OFFICIAL NOTICE OF DECISION

CITY OF ALBUQUERQUE
PLANNING DEPARTMENT
DEVELOPMENT REVIEW BOARD
2012

Project# 1008830

12DRB-70119 MAJOR – SITE DEVELOPMENT PLAN FOR BUILDING PERMIT

C-02

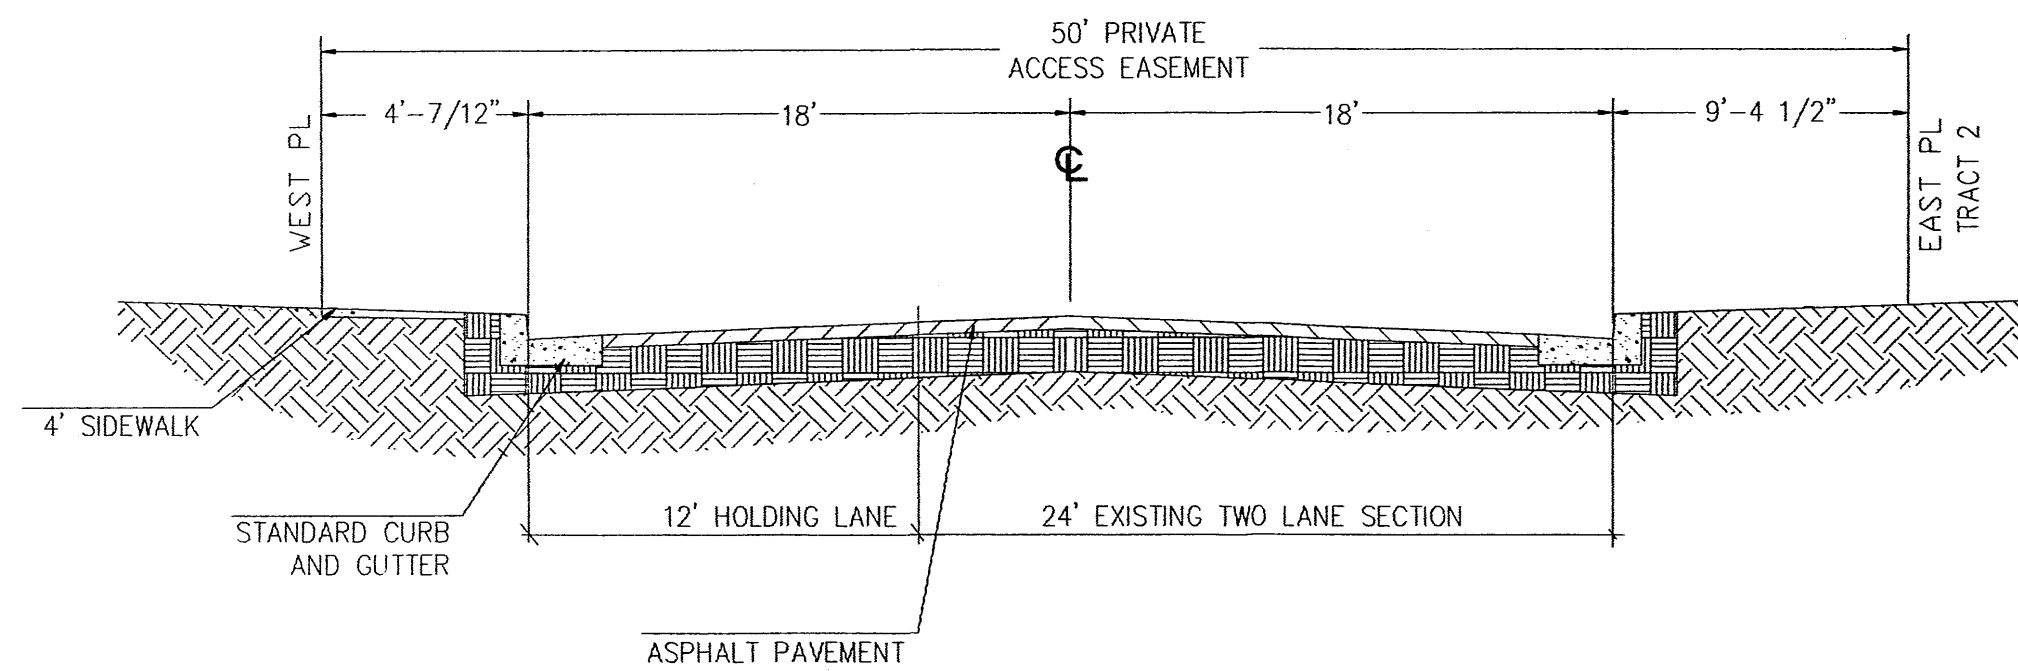
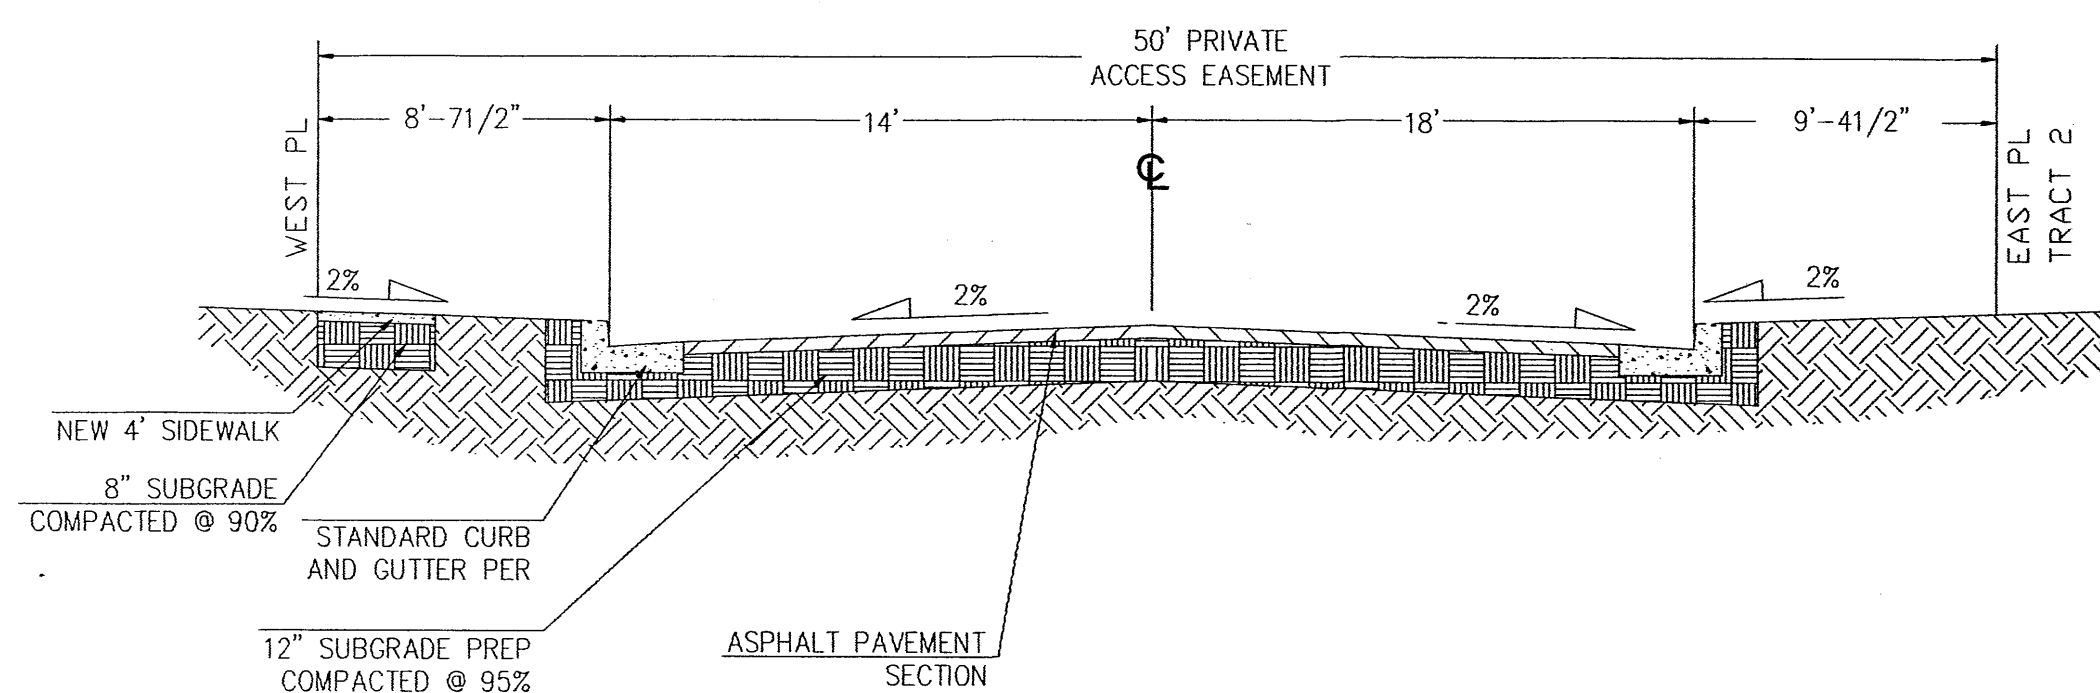
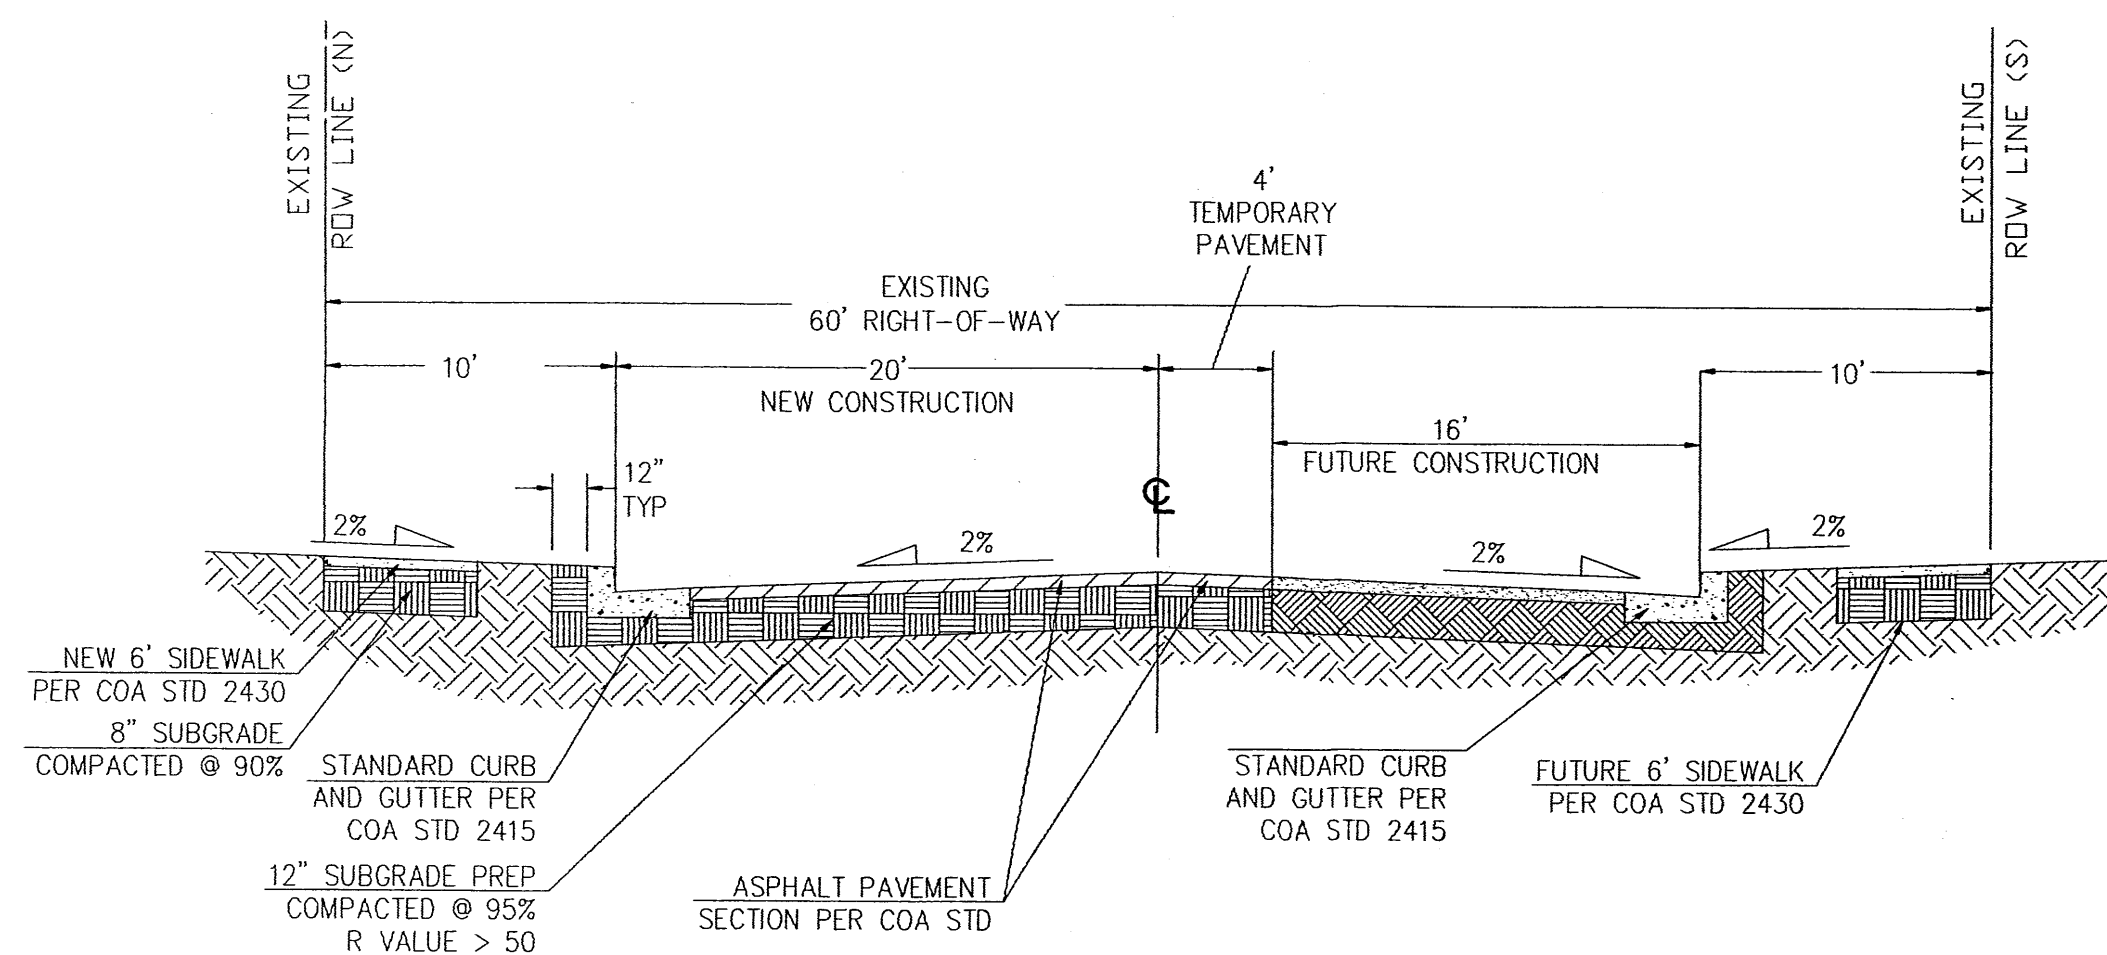
- Show all ramps and provide details.
- Please clarify the limits of all paving.
 - As-built information provided for Volcano Road NW define a 40'F-F roadway section, not 32'. The applicant is responsible for a minimum of 24' of roadway, not 20'.
